2024/1097**Applicant:** Mr & Mrs Travis**Address:** 14 St Helens Close, Thurnscoe, Rotherham, S63 ORD**Description:** Single storey side and rear extension to single storey detached dwelling

Drawing Title
Proposed Elevation Views
Client
Mr & Mrs Travis
Drawing No.
S630RD14 - 04
Date
02 / 2025
Scale
1:50
Drawn by
SGB
Checked by
Name

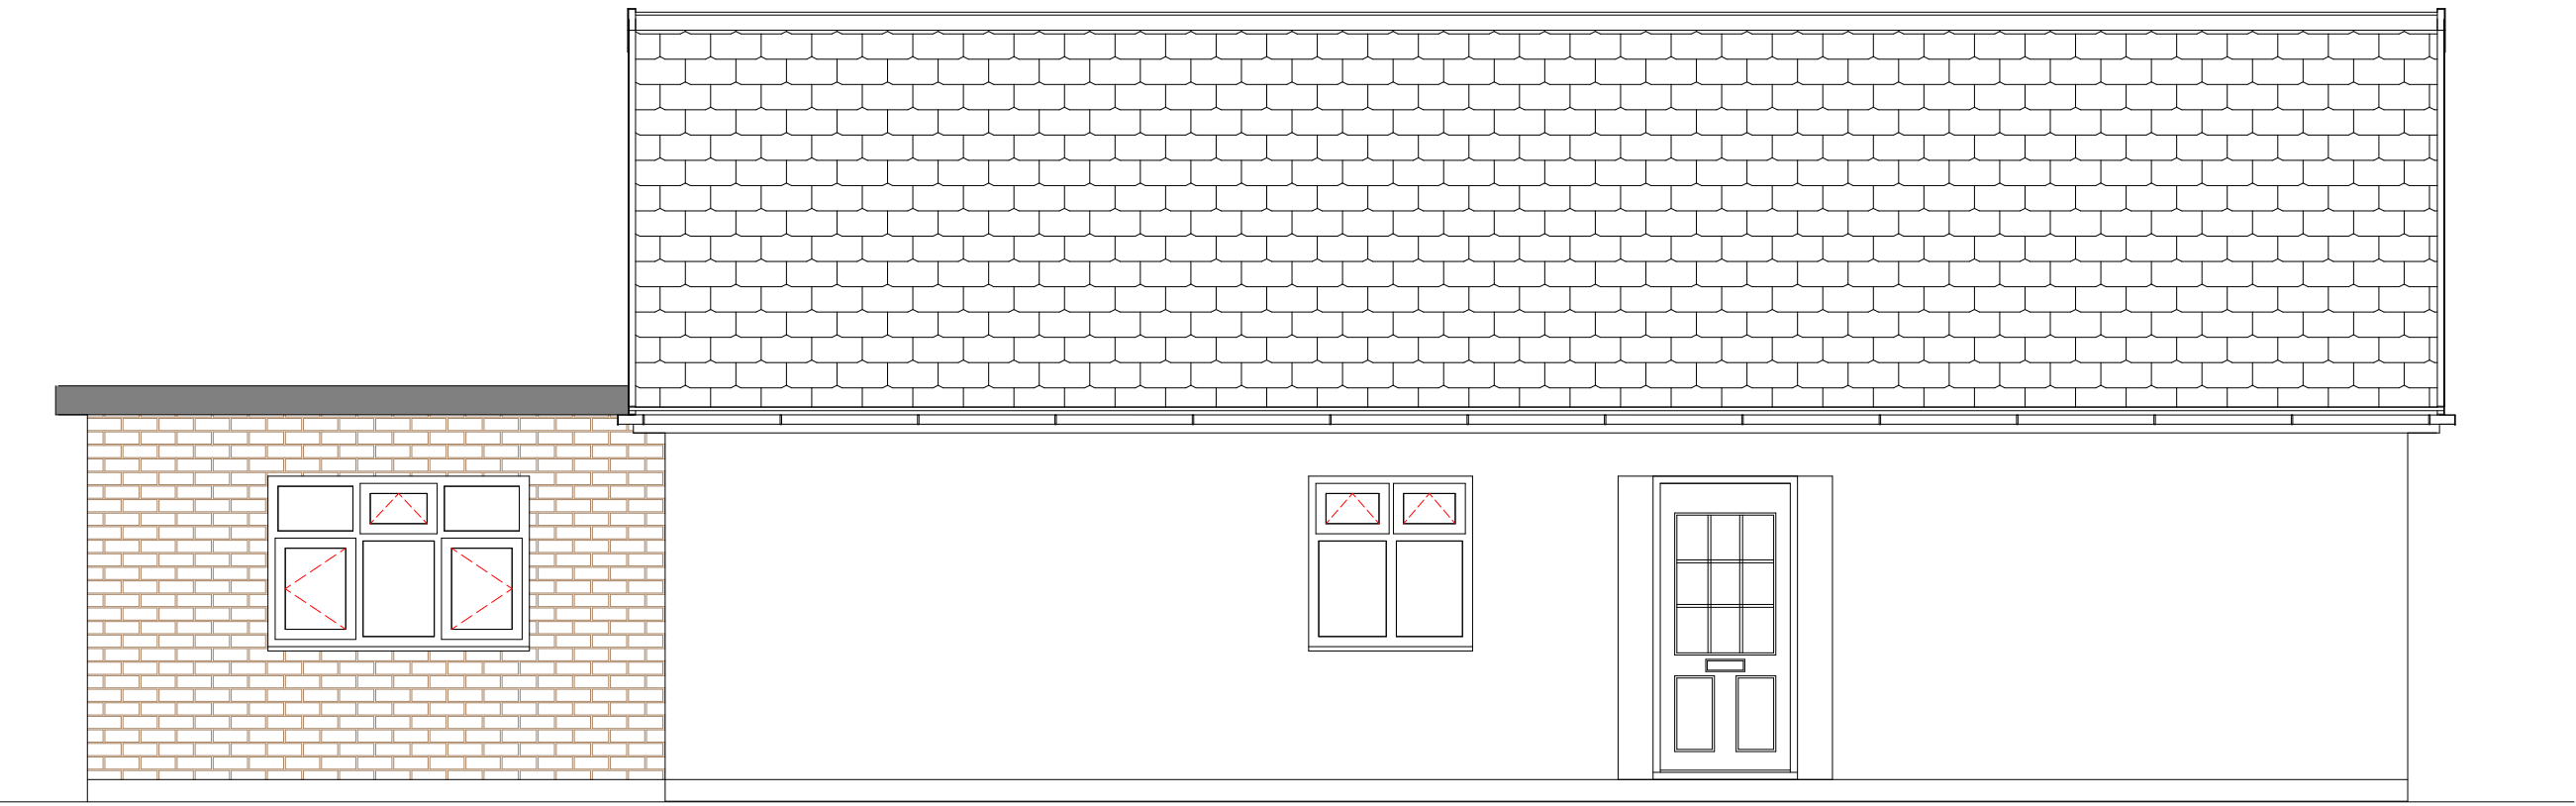
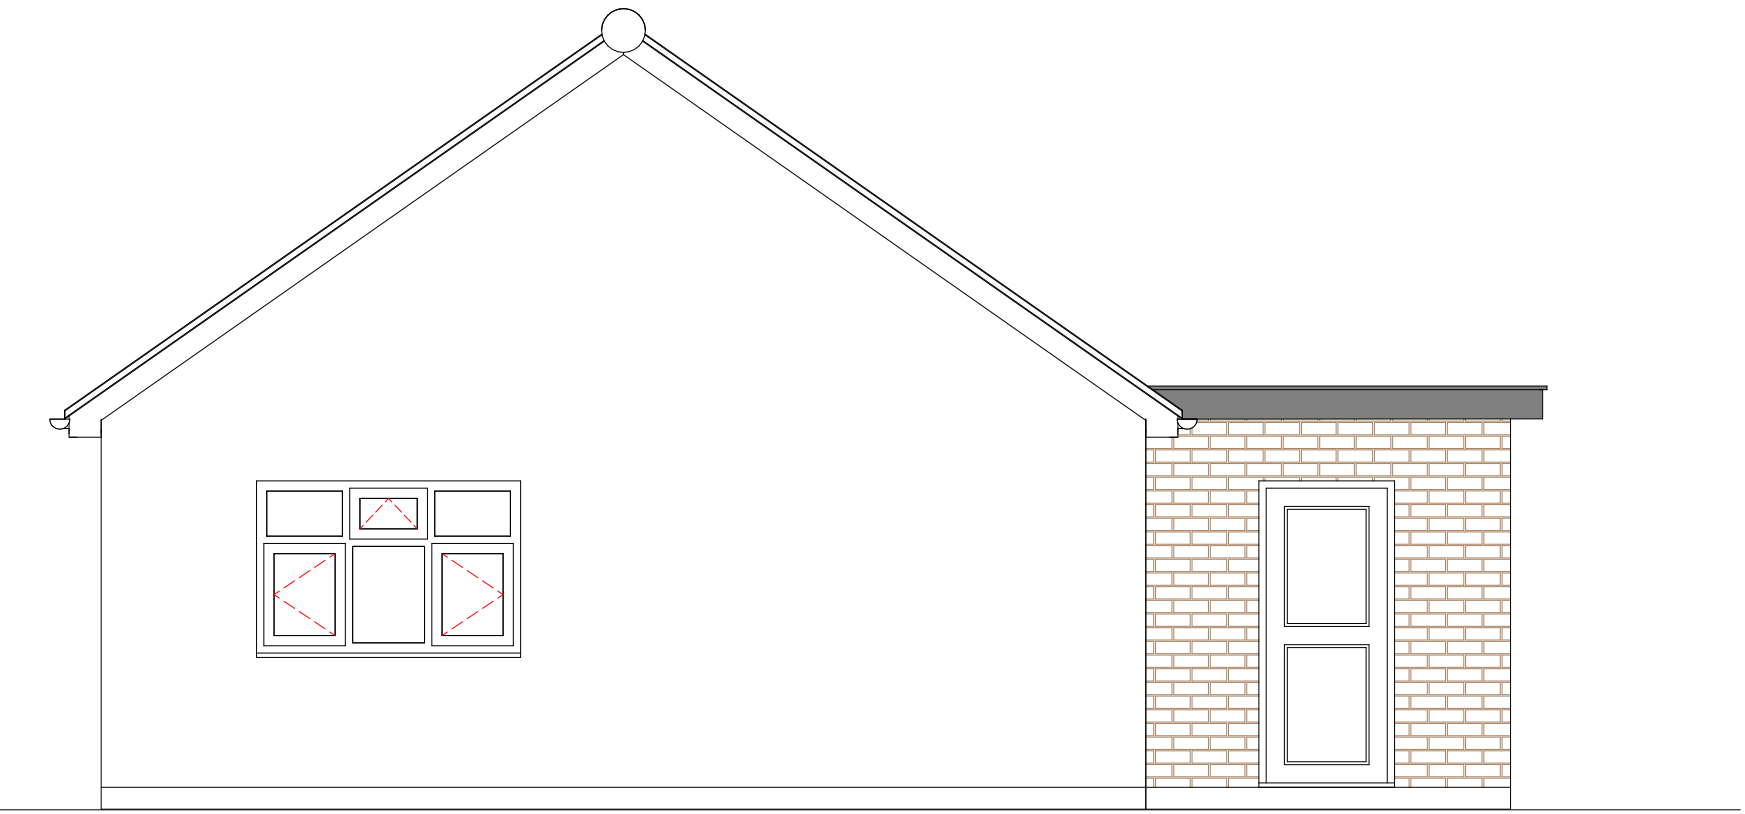
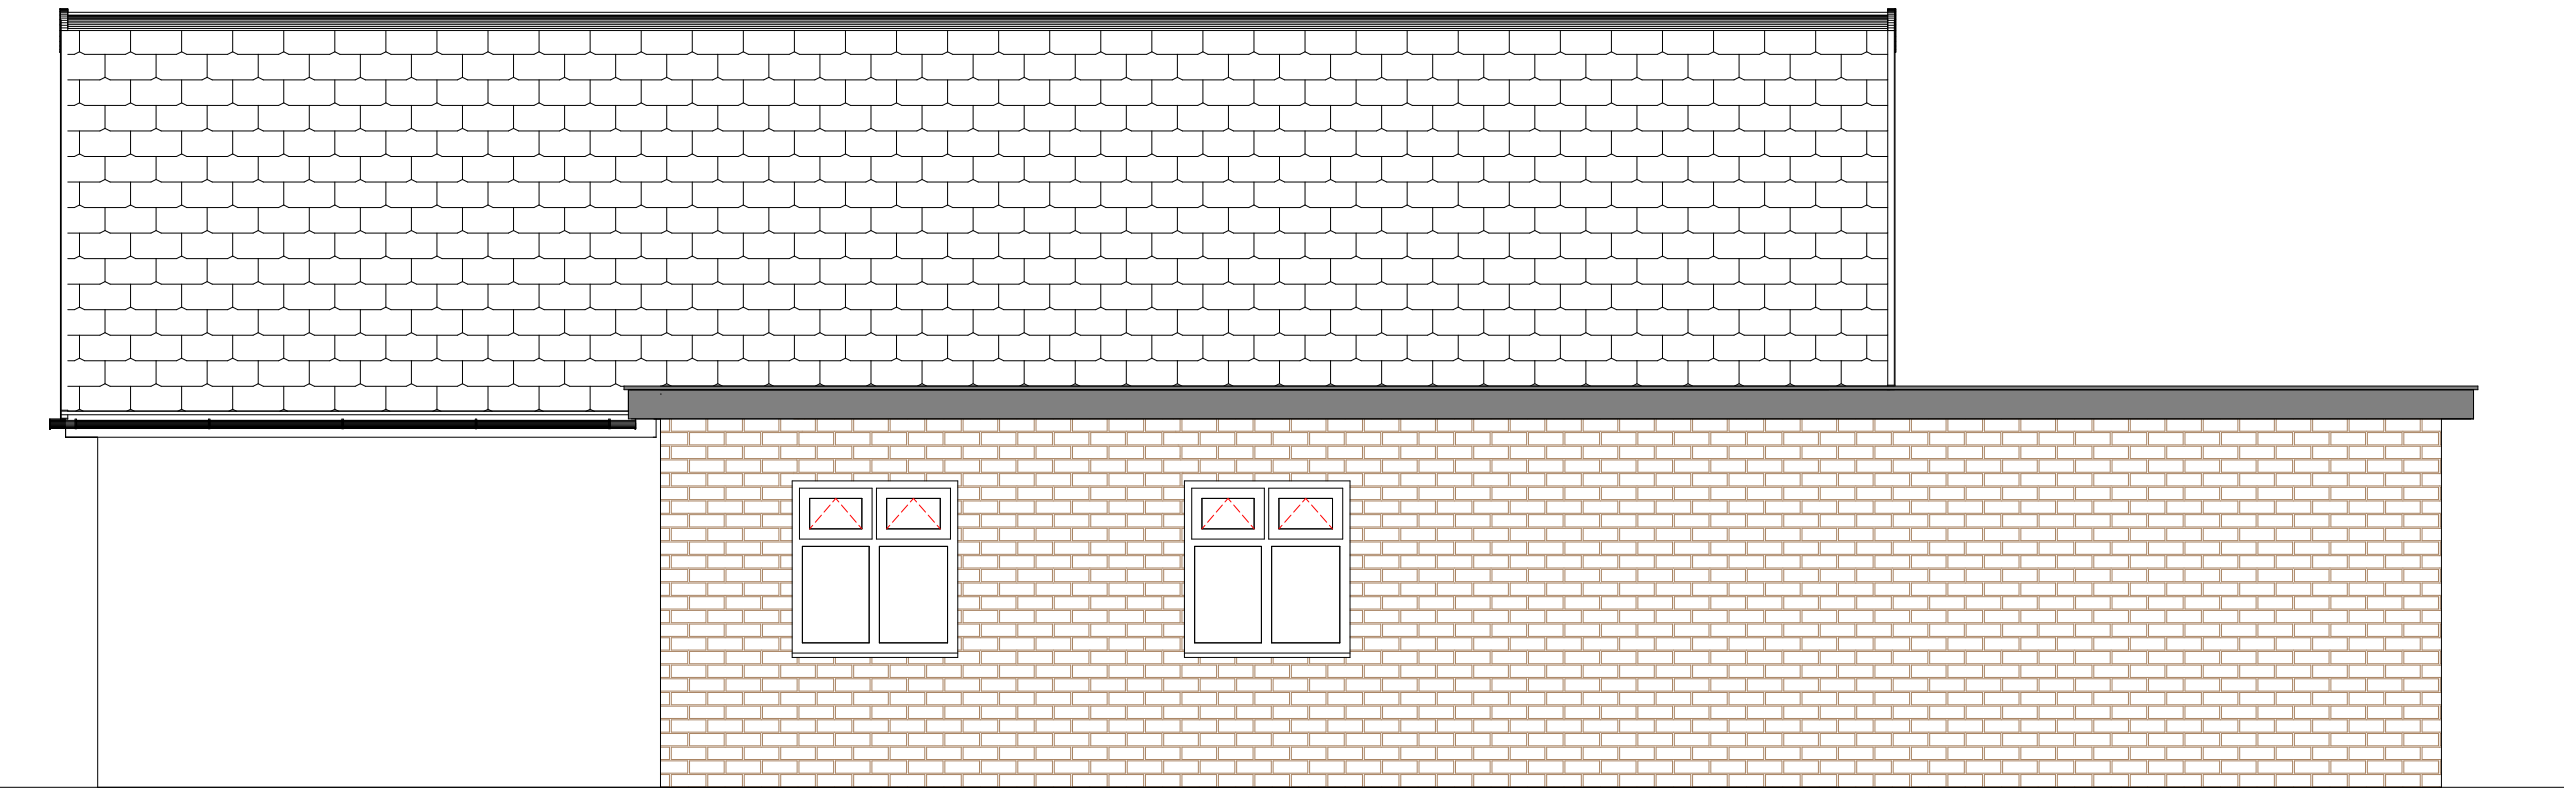
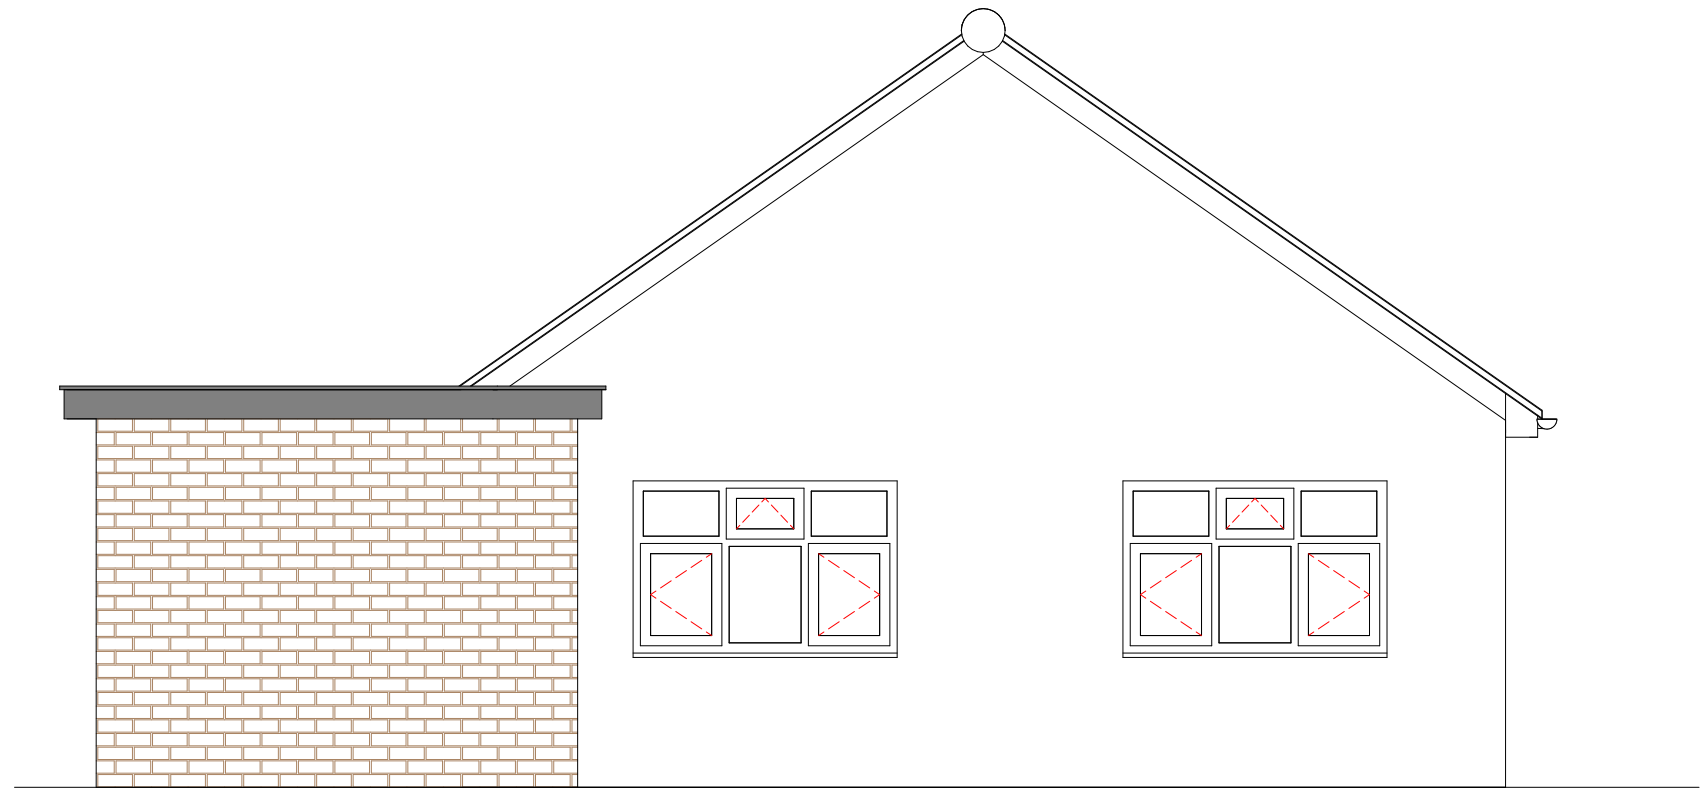
All existing roof and eaves heights have been checked on the existing plans and remain unaltered on the proposed plans. The side elevation described in the plans as the front elevation, along with the Front elevation described as Side elevation LH on the plans appear to be set at a lower ground level than their opposite elevations, resulting in a higher eaves and roof height of both the original dwelling and proposed extension.

Regardless of the ambiguity over the defined labels for elevations, what is in this report is considered to be the front elevation and which the plans refer to as the LH side elevation, would be considered at the principle elevation and as a result the original proposal was deemed inappropriate due to potential harm to the visual amenity of the street scene and the negative impact of the flat roofed, large extension to the original character of the dwelling.

The revised proposal, whilst not ideal, is acceptable given the proposed new location. Whilst not the most attractive of designs through lack of a pitched roof, the proposal is hidden from the broader front street scene and whilst visible from the rear, this would hopefully be diffused once third-party trees are planted. The proposal would also be visible from the adjacent green space but as it is not obtruse enough to cause a significant negative impact upon the green space. The height of the extension is also relatively modest and partially obscured by boundary treatments.

However, despite this, the proposal does not meet the general guidance for house extensions set out in the House Extensions and Other Domestic Alterations SPD. Specifically, the proposal does not meet guidance outlined in paragraph **7.19** which states *'The design of a single storey side extension should reflect the design of the existing dwelling in terms of roof style, pitch materials and should not have an excessive sideways projection (i.e. more than two thirds the width of the original dwelling)'*

However, similar extensions could be built under permitted development rights and similar examples can be found in the immediate area and across the borough. Also given the relatively modest size and height of the extension, and the non-prominent location, the proposal would not have a significantly detrimental impact on the visual amenity of the area in order to warrant refusal in this case. Furthermore, given the roof of the existing dwelling, and the size and positioning of the extension, it would be difficult to get a pitched roof to work without having awkward junctions and valleys.

As a result of the comments above, on balance, the amended scheme is acceptable.
